**From:** Simon Davis  
**Sent:** 14 April 2021 17:49  
**To:** Megan Green  
**Cc:** Chris Brake  
**Subject:** AL/20/21/PL - Wings Nursery, Lidsey Road, Woodgate

I write as promised with our comments on the application.

Urban Form Diagram

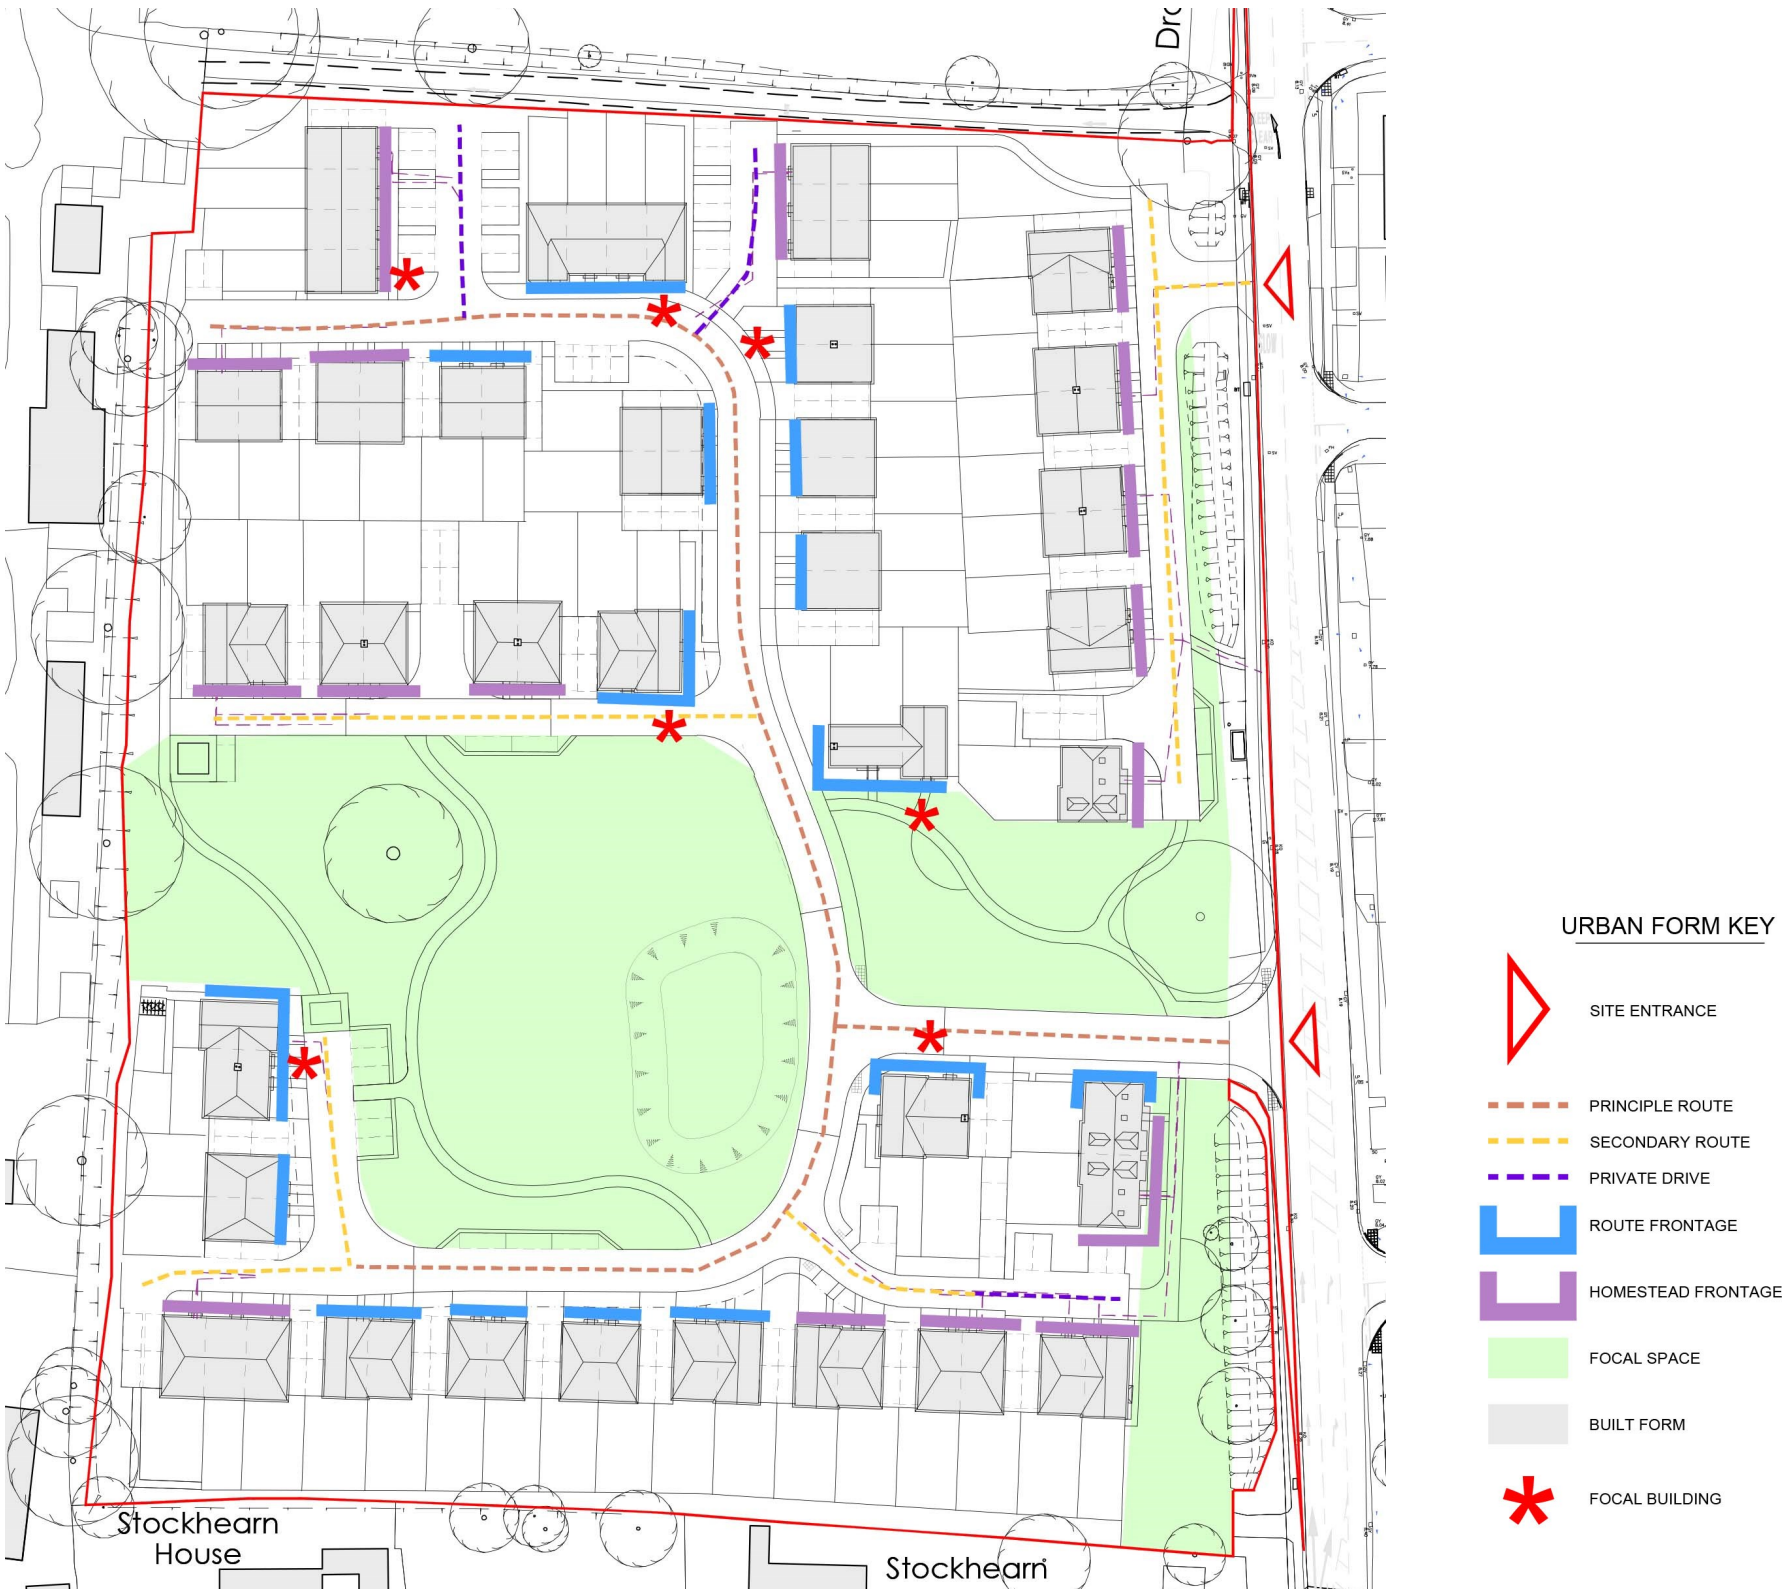
- I have the following issues with the layout:
  - The street trees in locations at/near plots 10, 35, 44-48, 51-53 don't appear to have room to grow being sandwiched by hard standing and prone to future pressure for removal due to their canopies being over parking spaces.

- There are some shortfalls versus the Design Guide interface distances within the layout:
    - plot 37 rear to 38's side is 12m (2m shortfall)
    - some rear-to-rear distances are in the range of 20-21m (so up to 1m shortfall)

- plot 19 front to 22's side is 10m (4m shortfall)

- plots 40/41 front to 44's side is 8.4m (5.6m shortfall)
- plots 36/37 front to 57/58's front is 12.3 (3.7m shortfall)
- The site density is 27.9/ha and this is in conflict with the Arun Design Guide which suggests 15-25/ha in village locations and states that this should decrease towards the edge of the settlement. However, it may still be possible to support the proposed density subject to the other concerns being resolved.

9 LAYOUT - PARKING

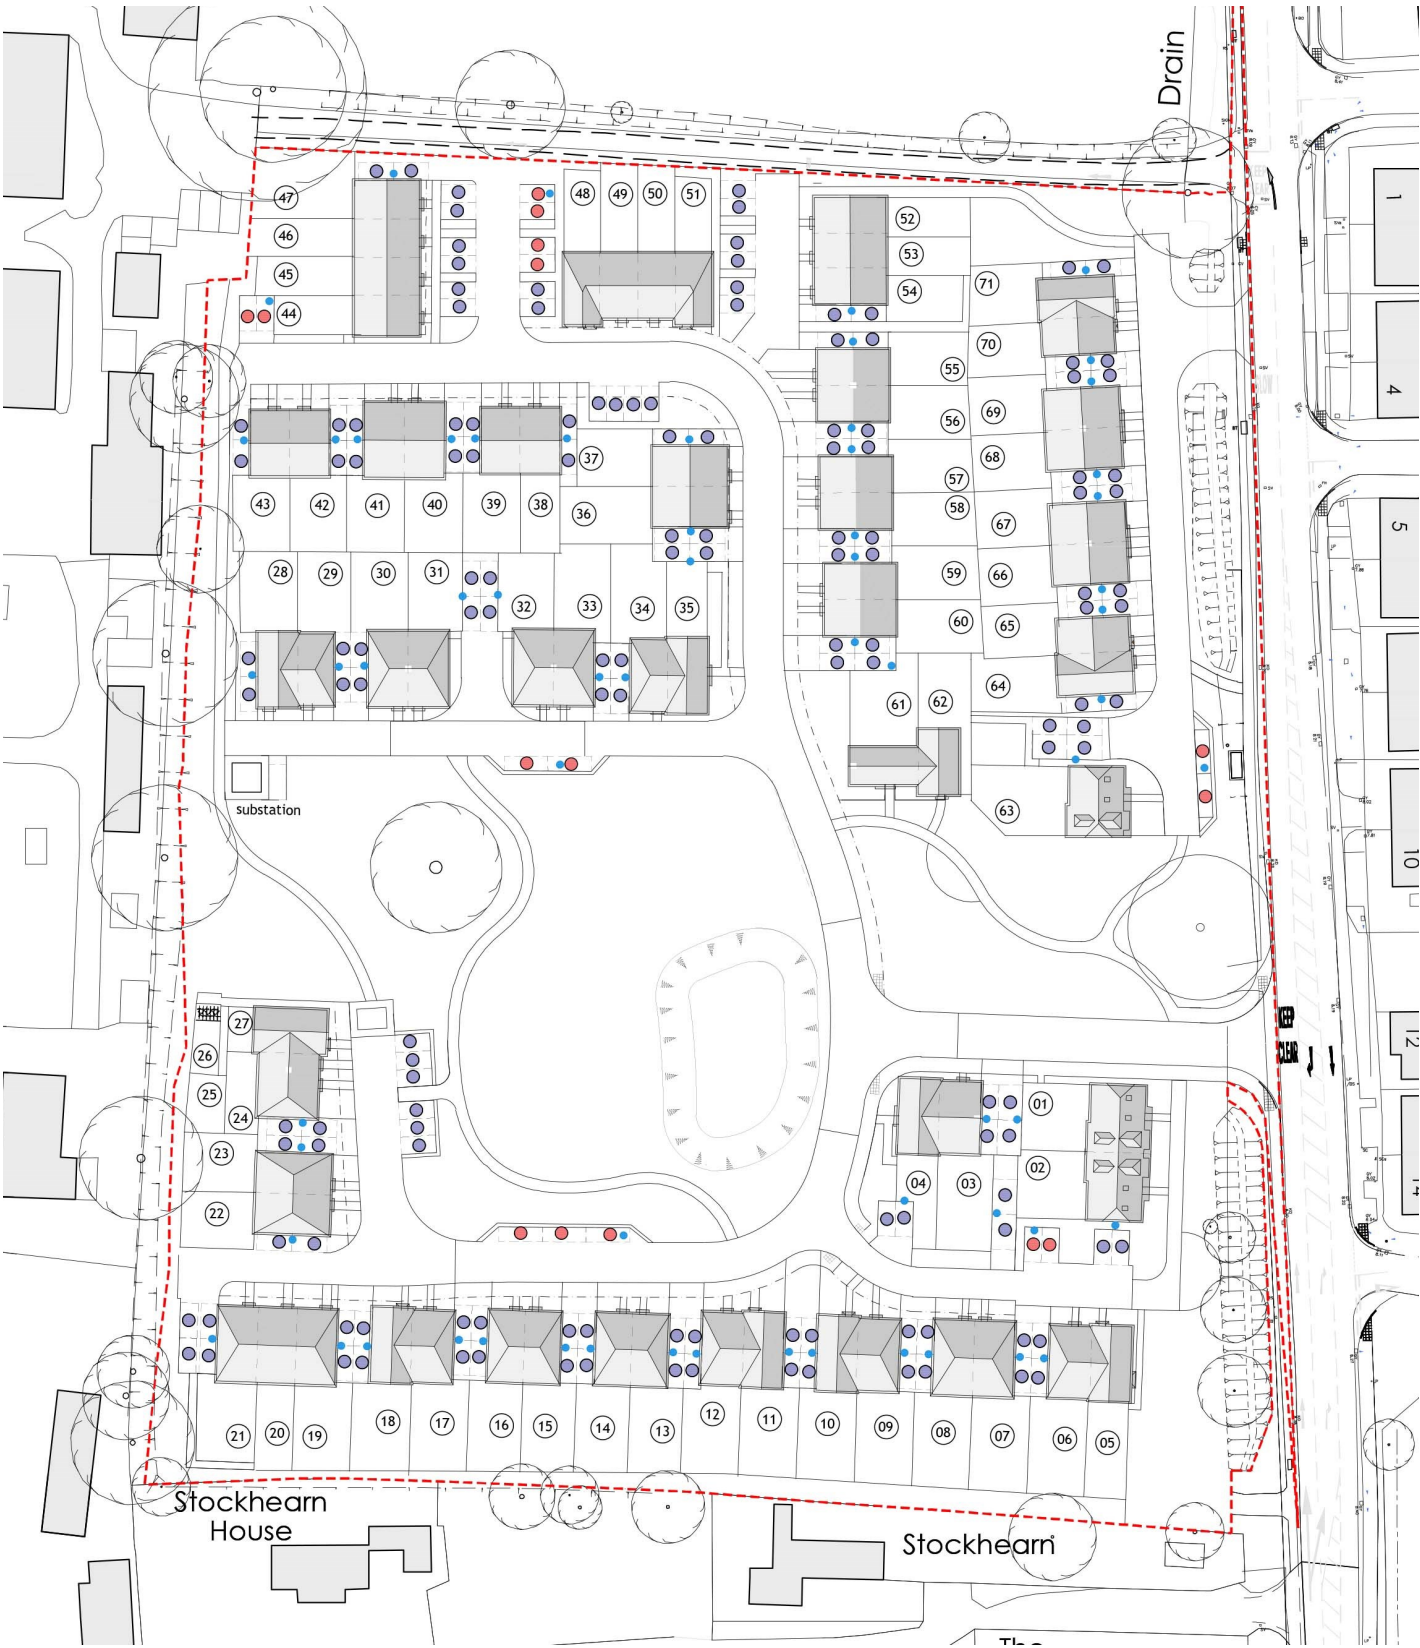
- The fronts of plots 42/43 look straight into plot 44's private garden
  - Plot 47 has its parking to the side but also 46's parking spaces to its front. This is not ideal from an amenity perspective.

- Plot 61 will likely park on the road not in the allocated spaces at the rear
  - Plot 62's spaces are accessed from a different road to its front
  - Plot 28 part faces a timber substation enclosure. Can this be moved backwards a little to enable a hedge/trees to be planted to its front with then access from the side.

- Make plots 44-47 all front south onto the road (so have the same building line as 48-51). Plots 44-51 should then all have on-plot parking.
- Redesign the arrangement of plots 61-63 so that all three front onto a road and have on-plot parking.
- The internal site interface distances need to be resolved so as to ensure that they are Design Guide compliant (or certainly much closer to the stated standards)
- I am informed that it is not necessary for plots 24-27 to have individual gardens so the subdivided area can be made onto a communal space.
- Relocate the substation or better screen it so that no house directly looks out onto it.
- Increase the space for street trees.
